M54 to M6 Link Road

PI Ref TR010054

Summary of Written Representation by Allow Ltd

Drawing file: TR010054 / TR010054-001020-TR010054 M54 6.3 Figure 2.7 Draft Masterplan Sheet 5 of 5.pdf

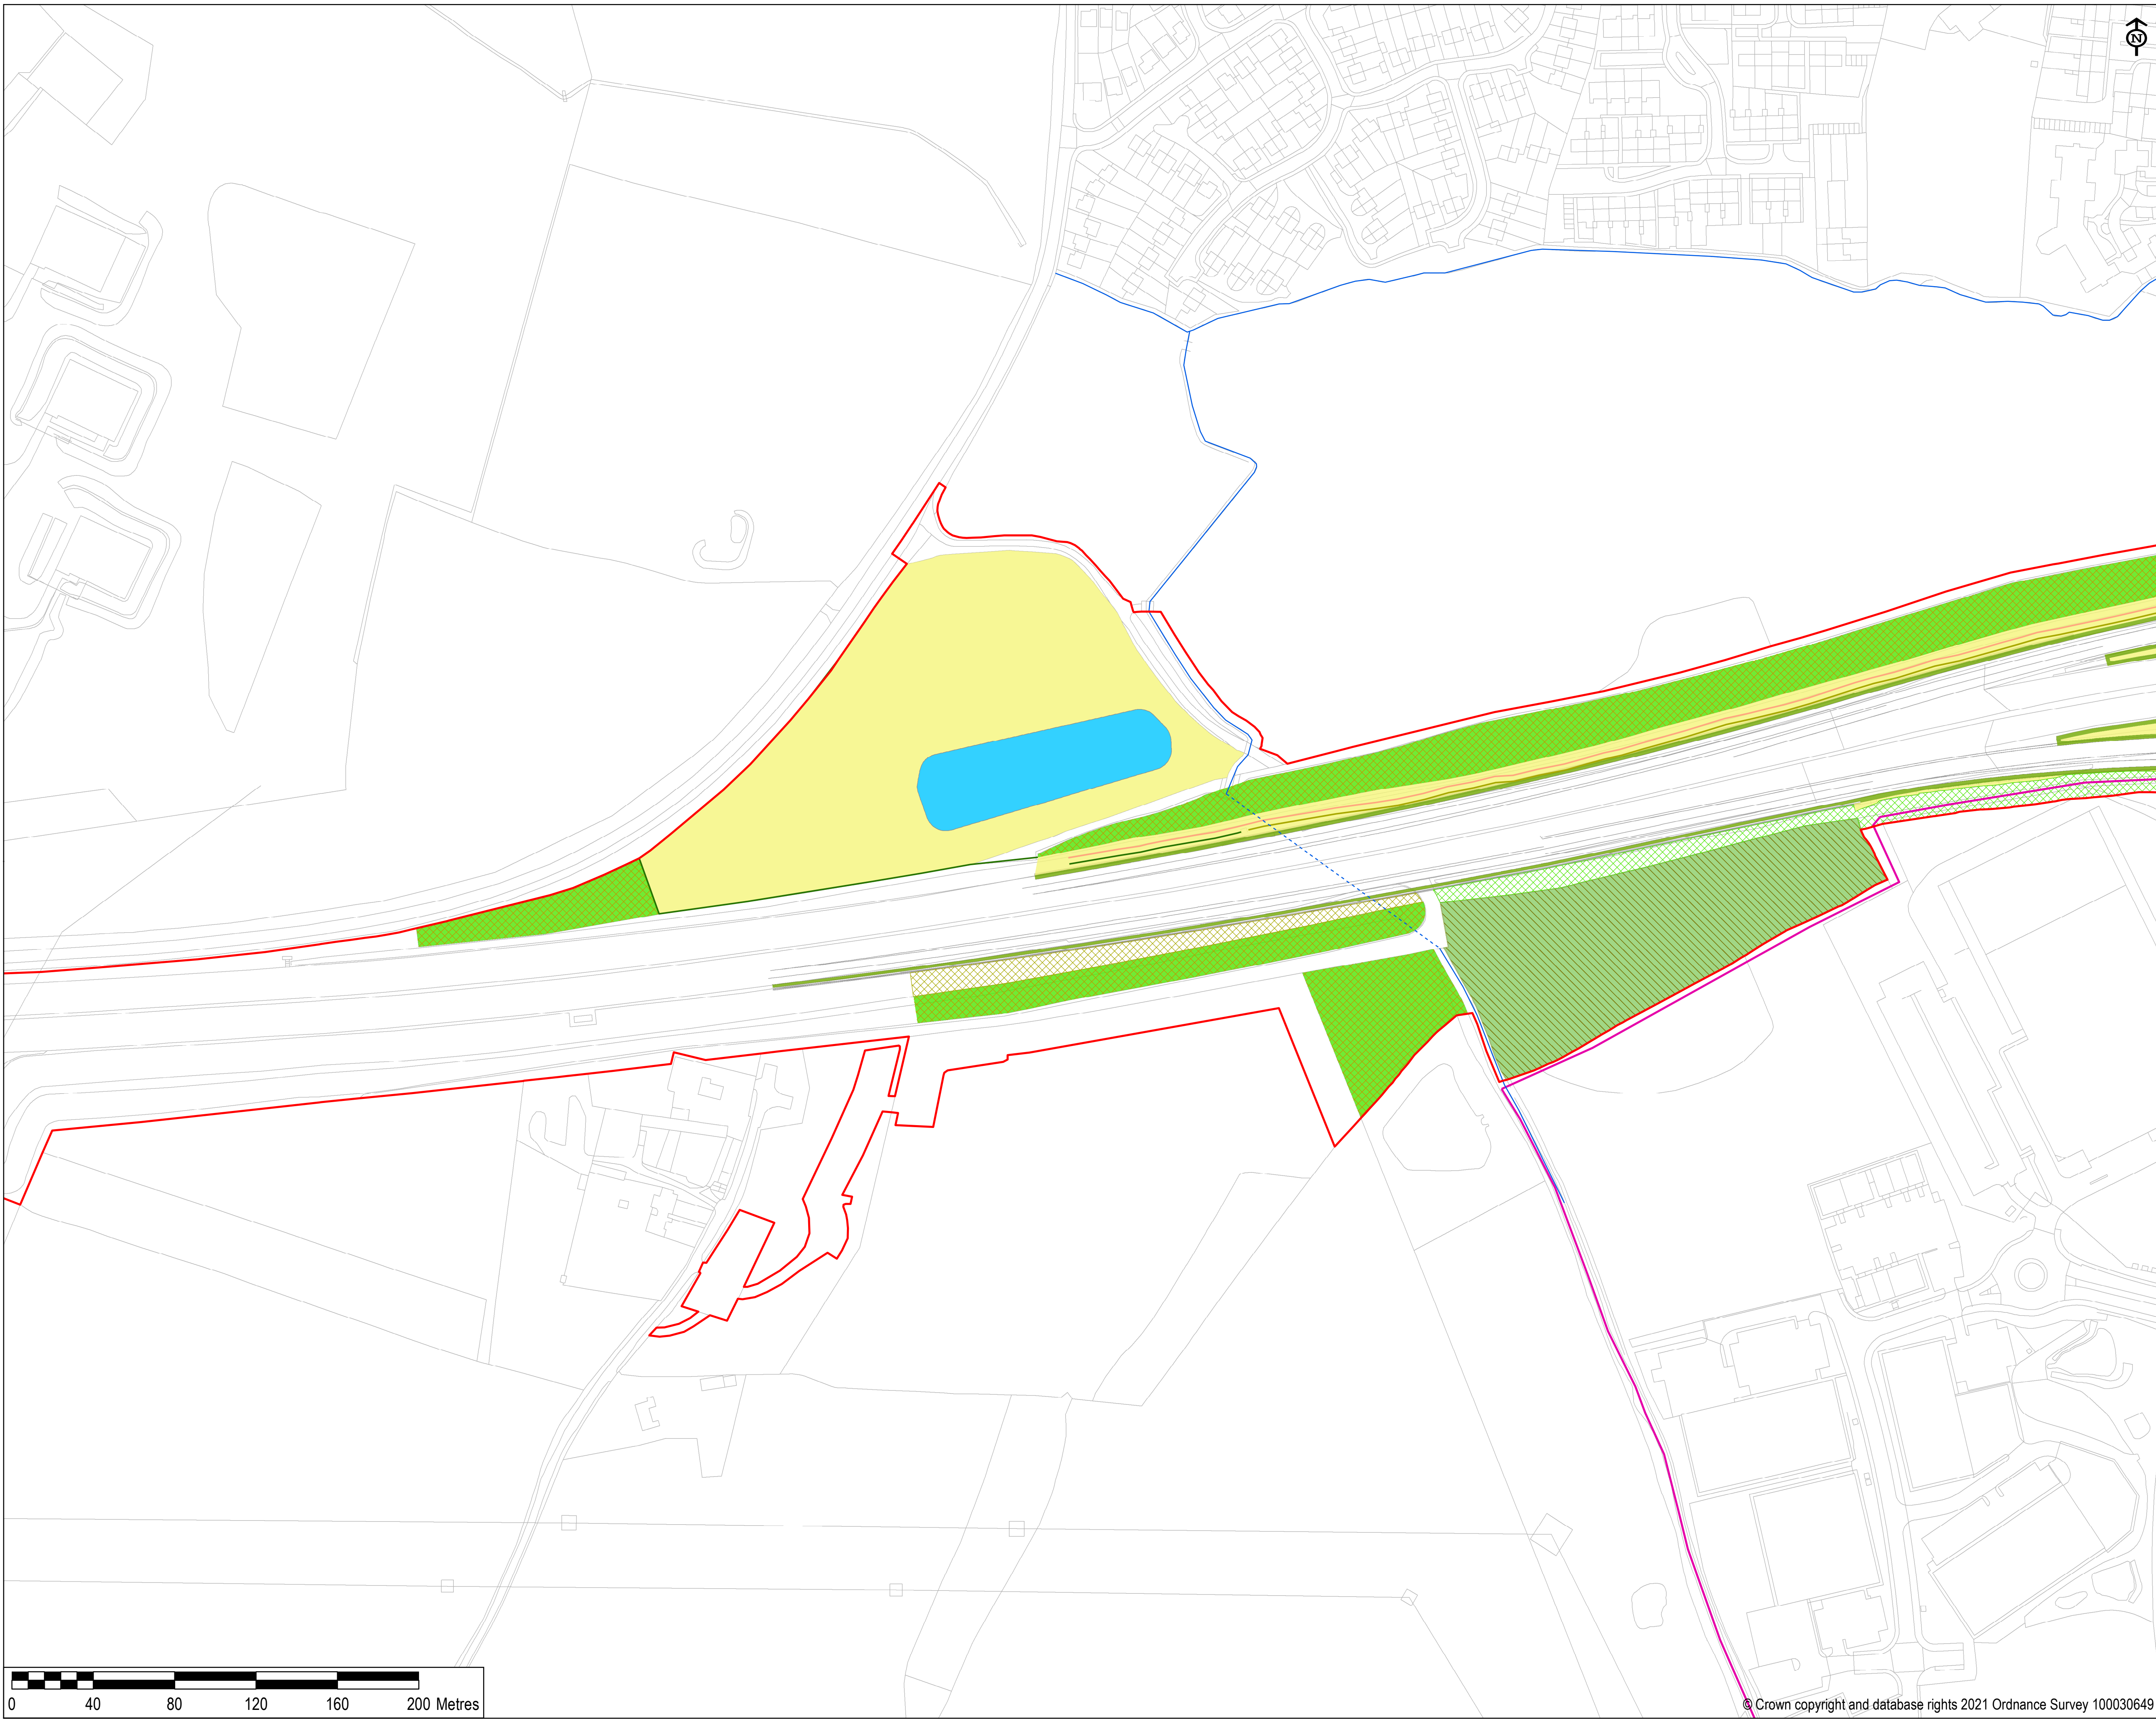
- ii. The large areas of woodland proposed on Allow's land (e.g. EW08) are located on the west of the proposed scheme. This will isolate planted woodland from other areas of woodland, plus Lower Pools SBI, in the landscape, reducing its effectiveness to contribute to existing ecological networks.

14. Other, more effective, locations to the east of the scheme should be examined which would not compromise the Historic Landscape Area of Hilton Park. It is recommended that woodland creation is redirected to the east of the proposed link road.

Drawing file: published-documents / TR010054-000244-TR010054 M54 6.2 Environmental Statement Figure 8.29.pdf

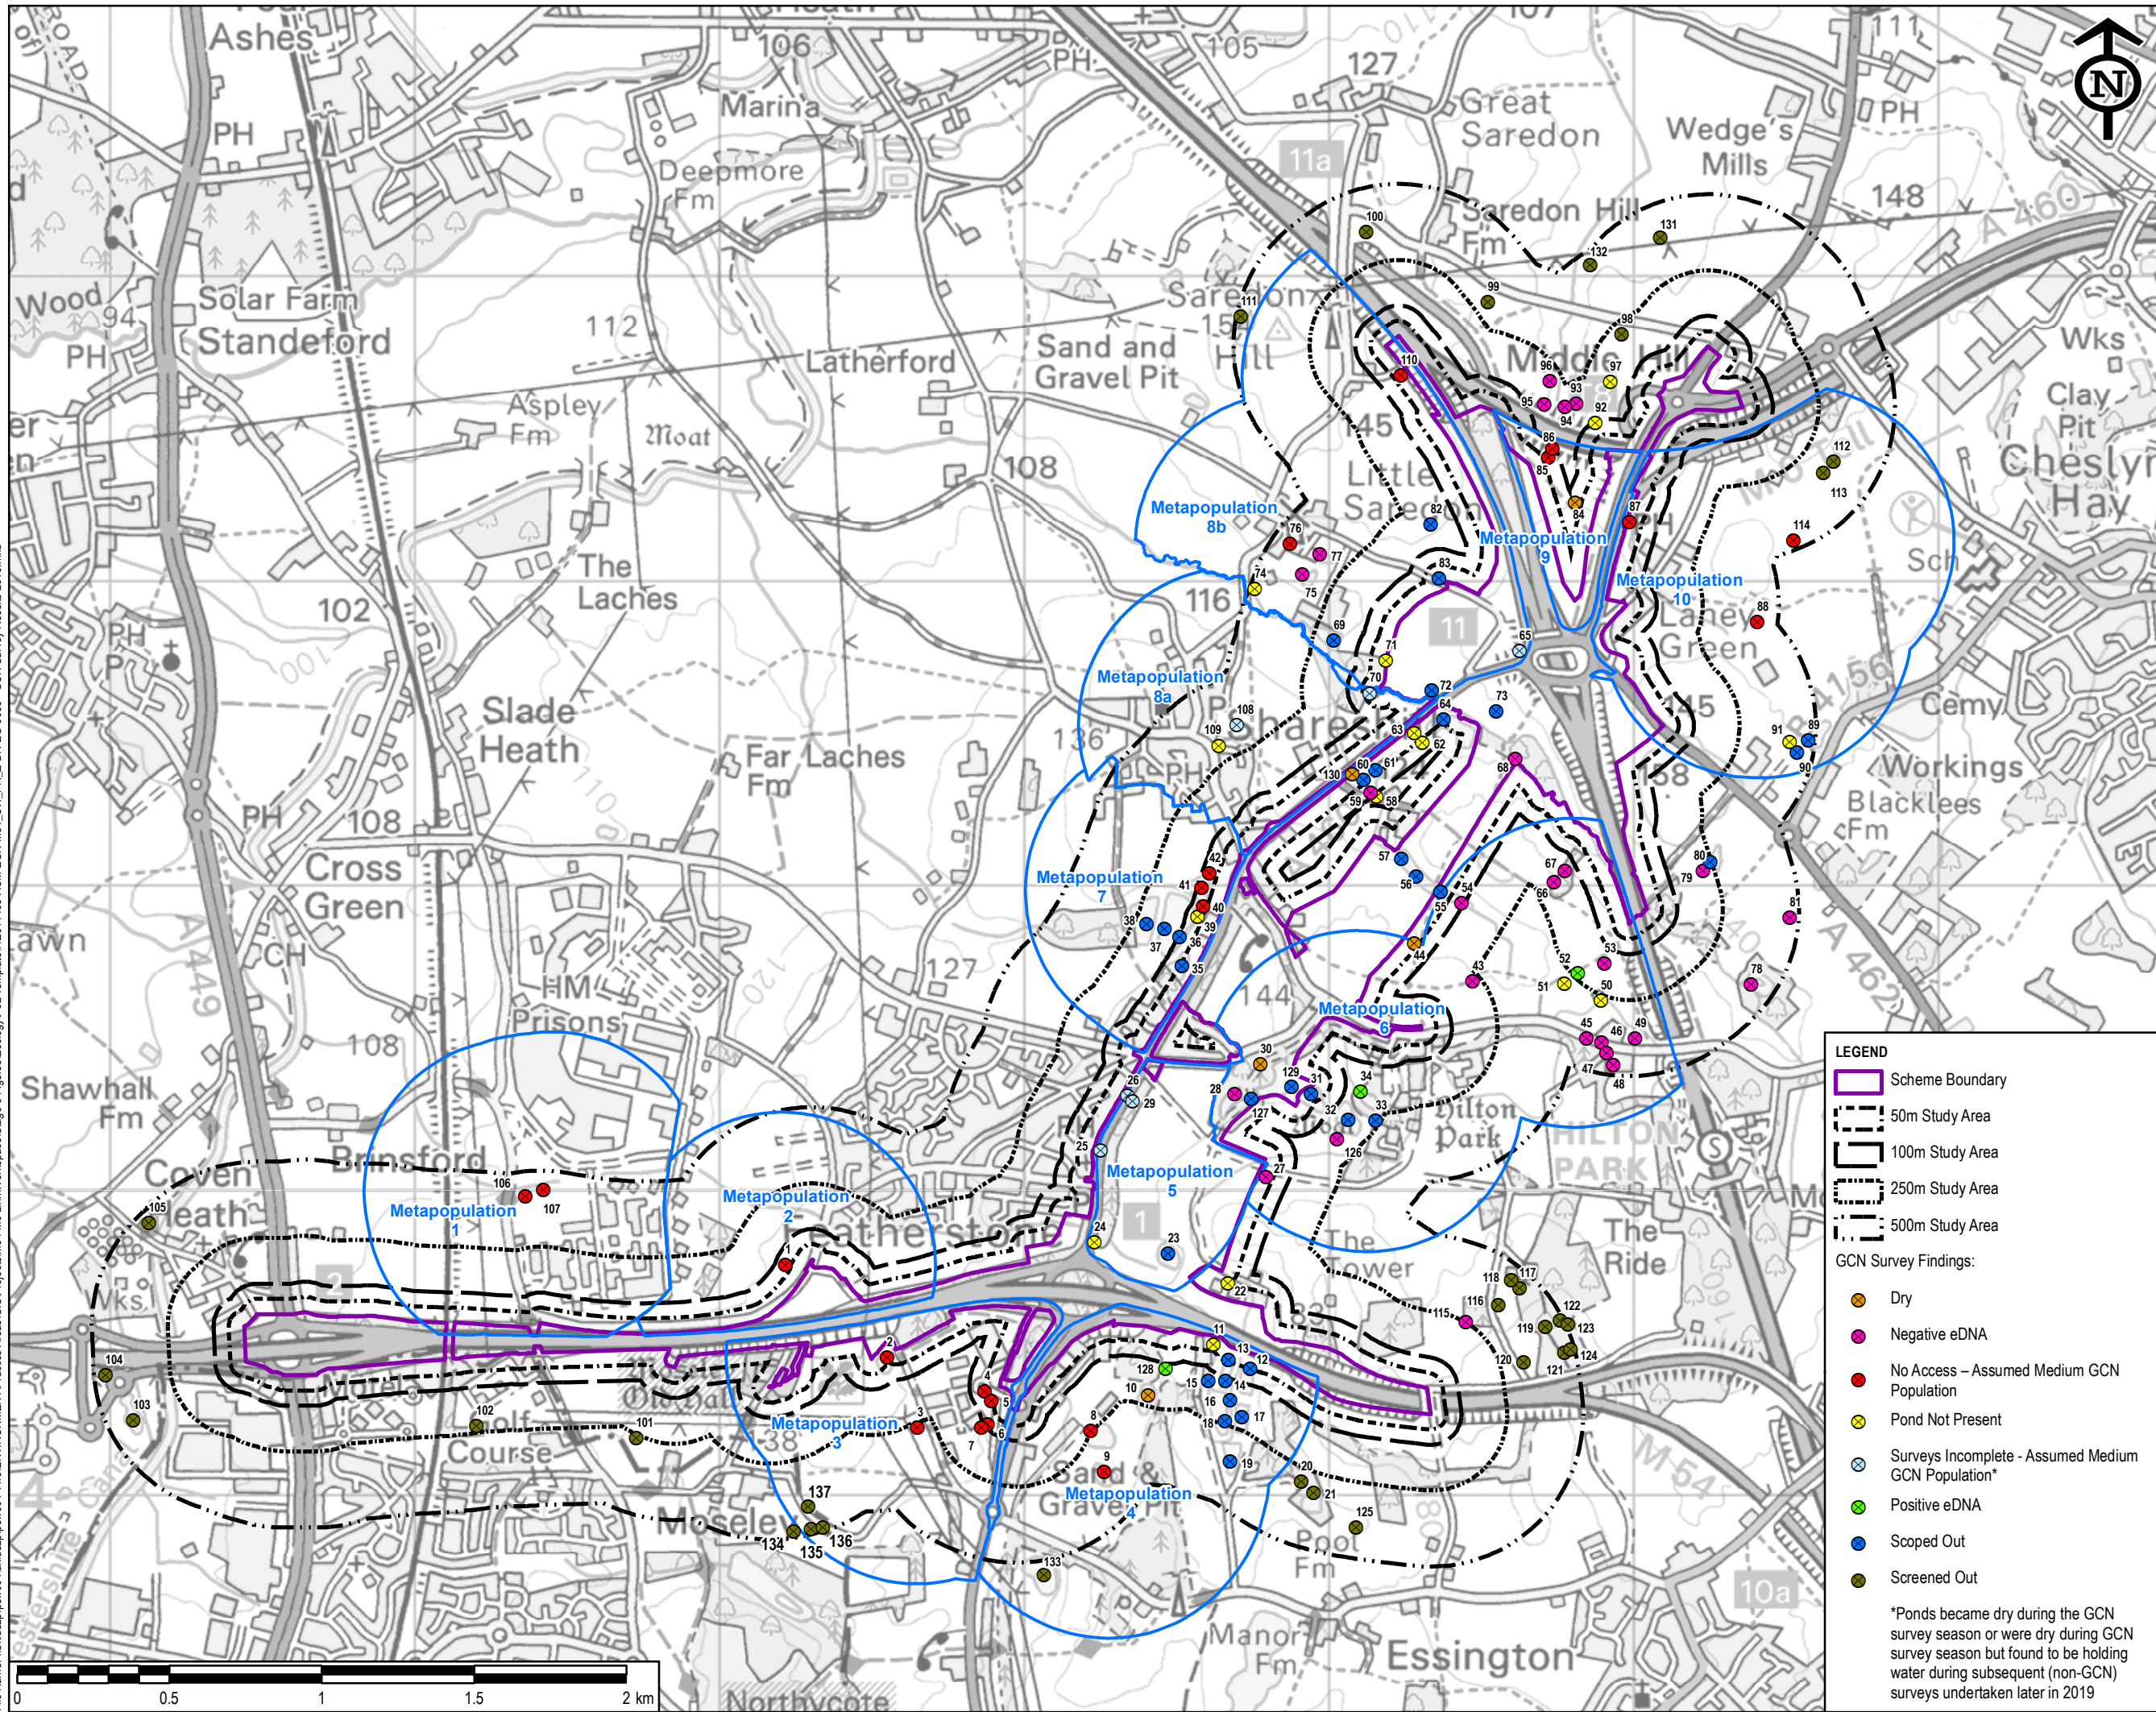
15. We append a review of the 2020 Great Crested Newt Data, undertaken by Aspect ecology. The concerns that arise are as follows:
 - i. A screening distance of 500m appears to have been used whereas 250m is appropriate, therefore it is recommended that this is re-visited.

- ii. An overly precautionary approach has been taken by the Applicant.
- iii. Ponds known to support GCN are to the east of the scheme and Mitigation ponds are proposed to the west of the scheme.
- iv. The 2020 results have confirmed that fewer compensatory ponds are required.
